Loreto Kirribilli – Western Precinct

PRELIMINARY BCA ASSESSMENT

REPORT 2016/1744 R1.4

Loreto Kirribilli – Connectors to Northern, Eastern and Southern Precinct

title  
**Elevations**  
**Elevations - Northern Precinct Connector**

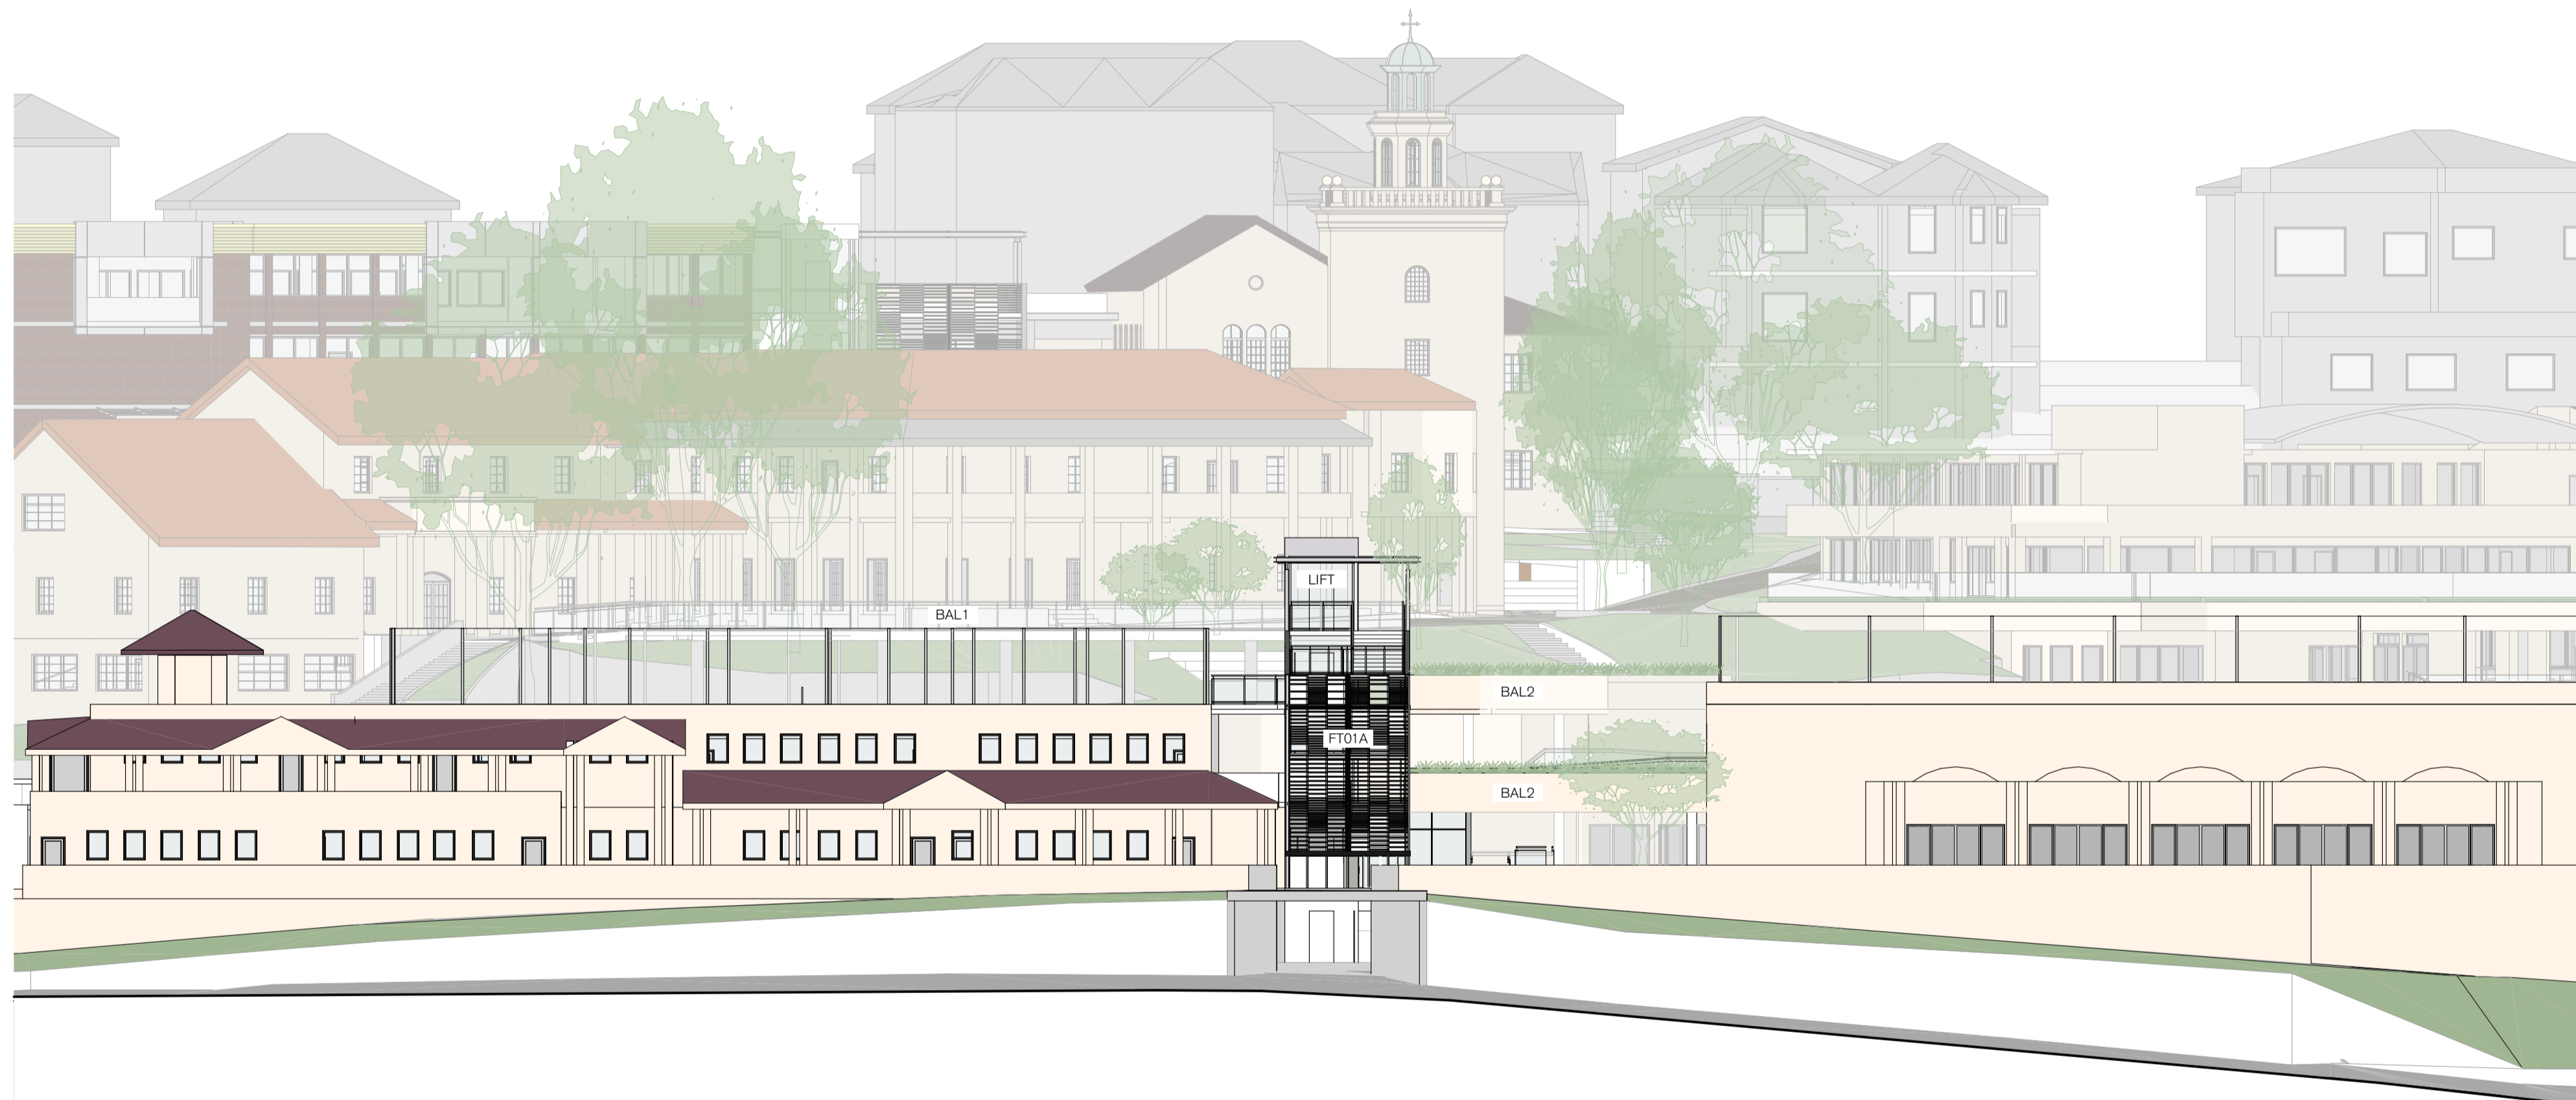
- The fire walls separating the compartments will not fully comply with Clause C2.7 due to the glazing and glass doors opening into the foyer of the Centenary Hall. A fire engineered solution is proposed to be investigated for a performance based fire wall for the separation of the buildings. It is proposed that the fire wall design separates the two buildings so that they may be **treated as separated buildings for the purposes of Section C, D and E of the BCA.**
- The new external walls are required to be provided with spandrels complying with Clause C2.6 to stop vertical fire spread. Spandrels are not required to external walls only serving the lobby.

- A lift connecting more than 2 storeys is required to be in a fire resisting shaft achieving an FRL of -/120/120. Fire separation between the class 7a carpark and the class 9b levels above is also required to be achieved through the lift shaft. Should a glass lift be proposed, a fire engineered solution will be required to be investigated to determine if it can be achieved on a performance basis. The fire engineering investigation would need to take into account the fact that the glass lift landing door would breach the separation between the class 7a carpark and class 9b portion above. If compliance cannot be achieved on a performance level, a fire rated lift shaft and lift landing doors will be required in accordance with Clause C2.10 of the BCA

- The roof is required to be non combustibile and be provided with a ceiling immediately below the roof that has a resistance to the incipient spread of fire of not less than 60 minutes. A fire engineered solution can be investigated to remove the requirement to have a 60 minute incipient spread ceiling below the roof serving the stairway/lobby.

Western Precinct Envelope

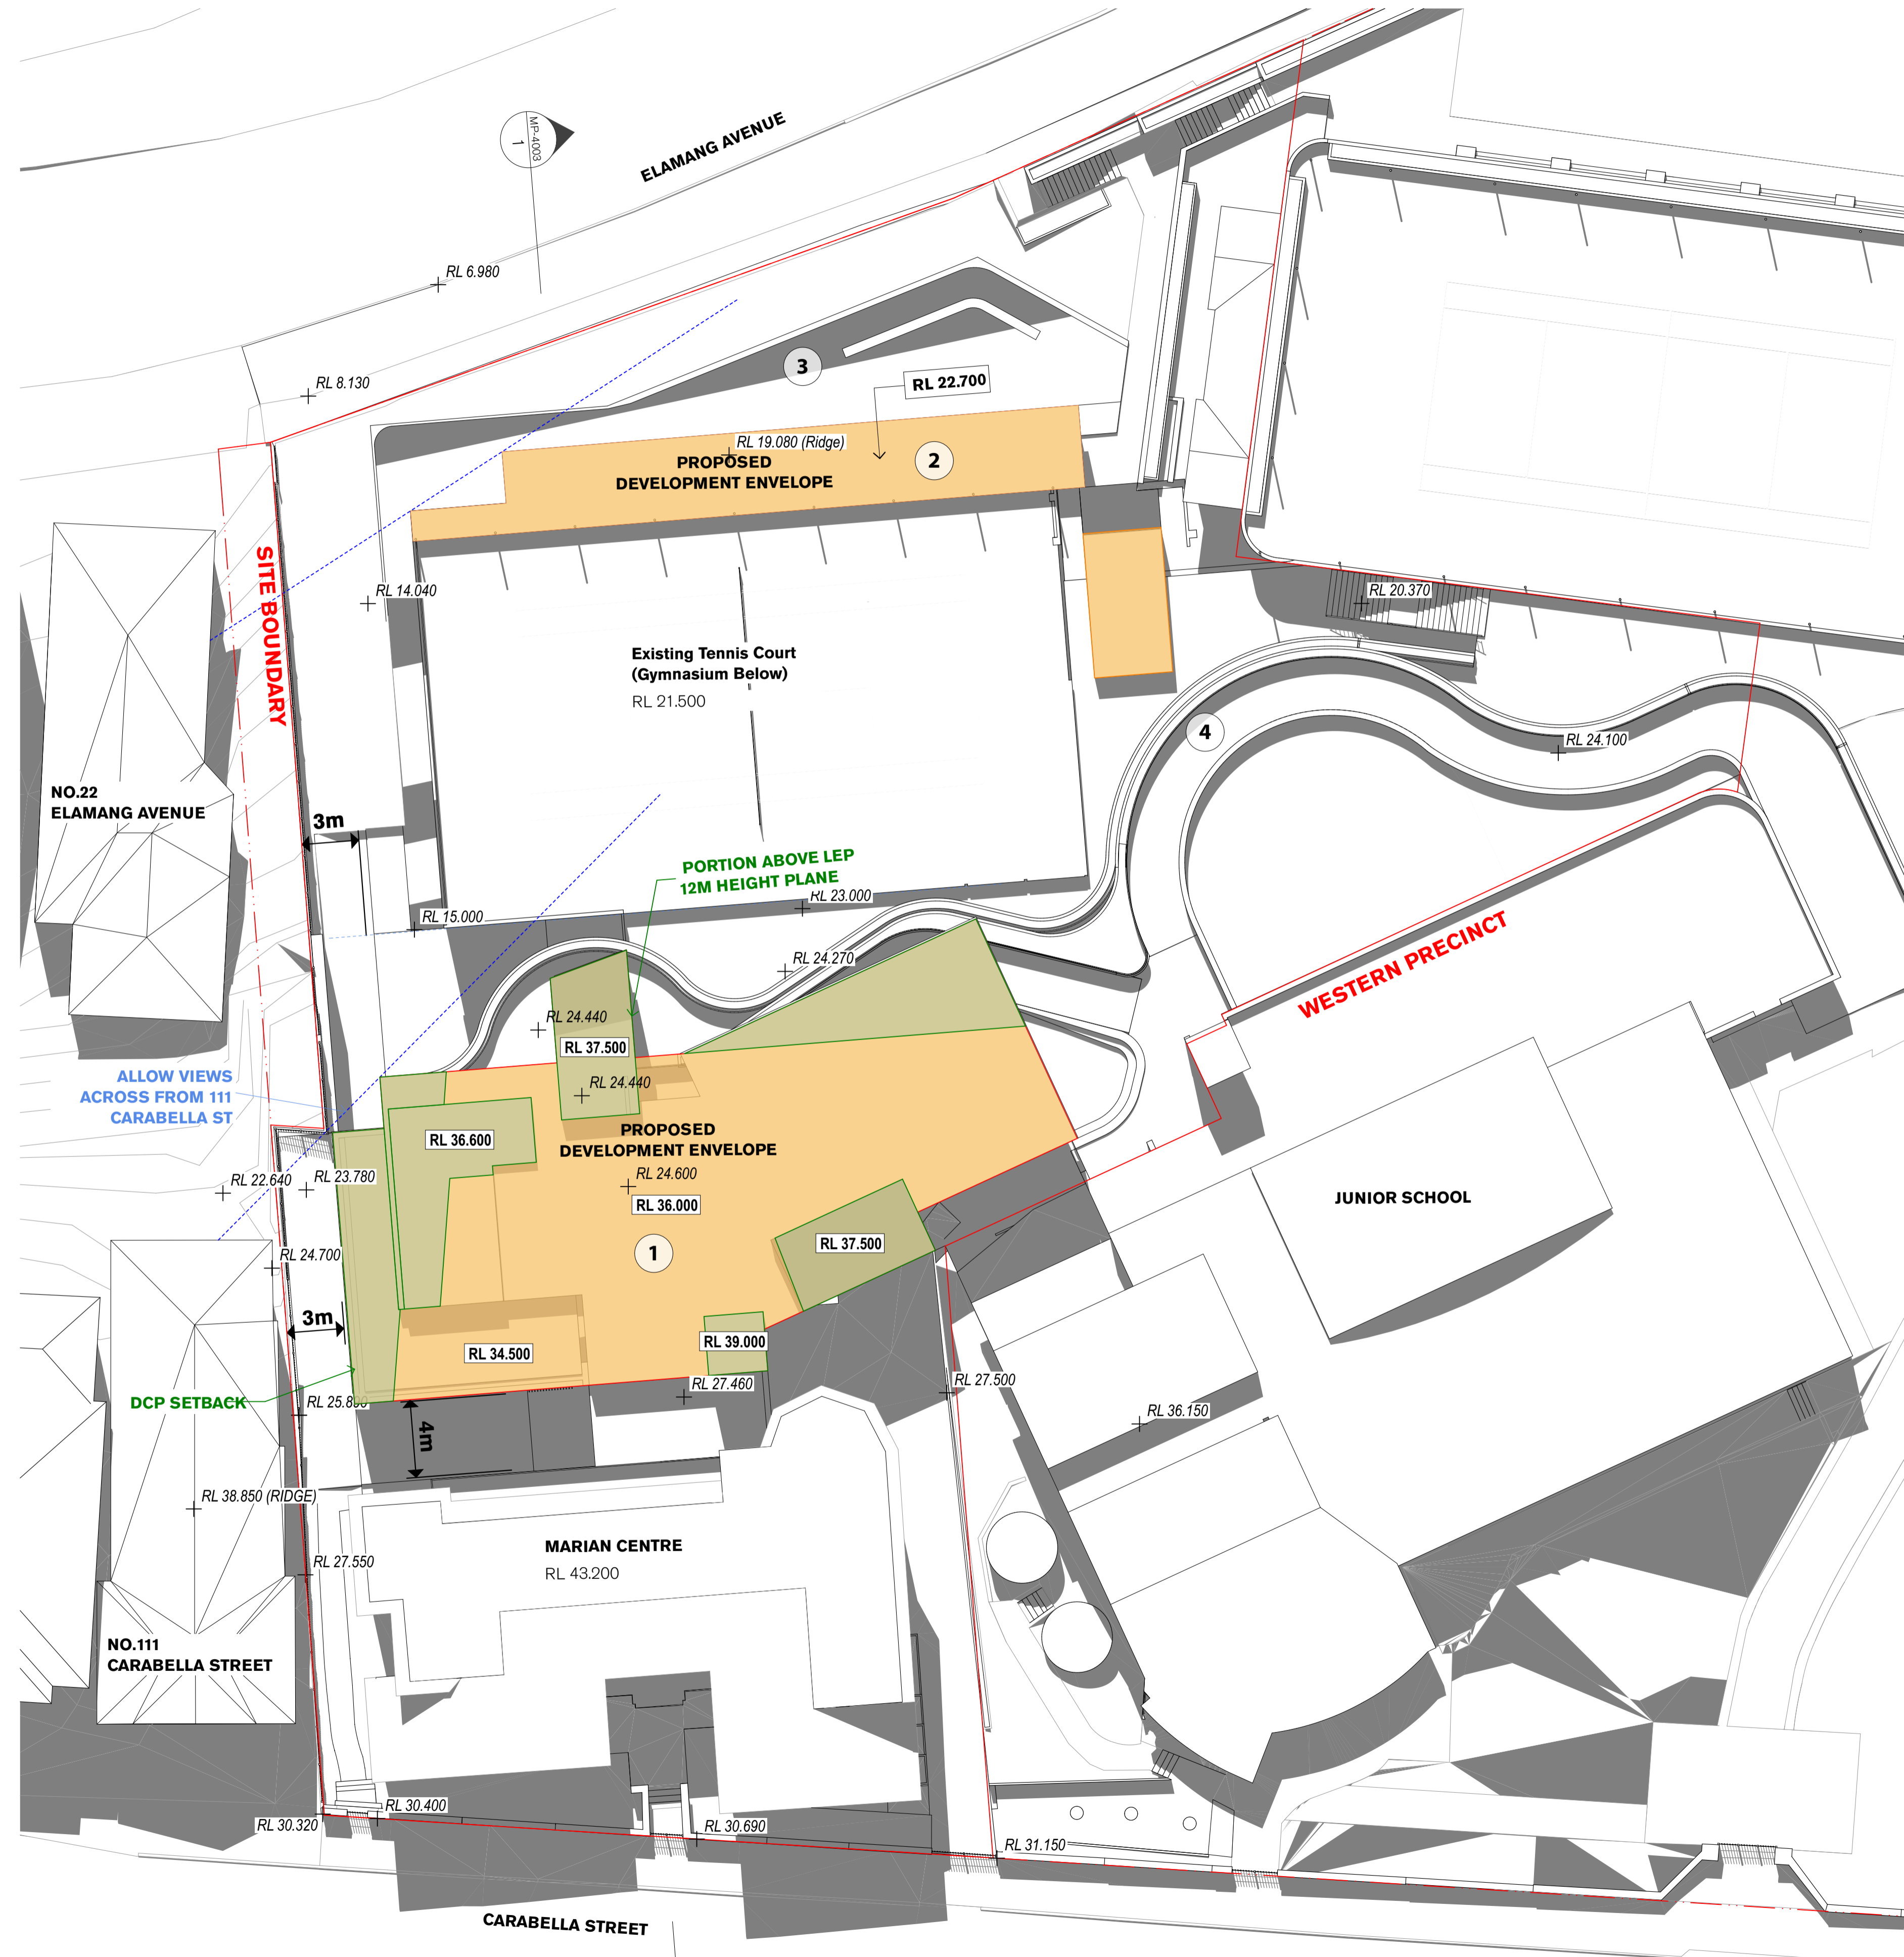
- The external walls of the new innovation centre and the existing Marian Centre are less than 6m apart in some areas. As a result, any openings that are within 6m of the external wall of the opposite building must be protected in accordance with C3.4 (i.e. fixed shut windows with drenchers, self closing fire doors, or self closing doors with drenchers). A fire engineered solution can be investigated where compliant protection of openings is not provided.
- Furthermore, the glazed openings on the ground floor clouded below, occupy more than 1/3 of the external wall they are located in. A fire engineered solution is required to be investigated.

- The communication stair currently connects 7 storeys. Clause D1.3 of the BCA requires stairways to be fire isolated when they connect more than 3 storeys. The fire engineer will not be able to justify an open stair, however preliminary discussions should be had with the fire engineer to determine if it is capable to provide a performance based isolated stair with drenchers, toughened glass and automatically closing doors. This will need to be investigated with the fire engineer to determine if it is possible.

- In accordance with Clause D1.7, where the discharge from either of the two exit stairways necessitates passing within 6m of an opening in an external wall, those openings must be protected in accordance with C3.3 i.e. windows fixed shut with drenchers and self closing fire rated doorways. The protection is only required where the path of travel is exposed to openings measured at right angles. A fire engineered solution can be investigated to reduce the extent of protection if possible. Note, the existing low level louvers in the western elevation of the existing gymnasium should be filled in to achieve an FRL of 120/120/120.
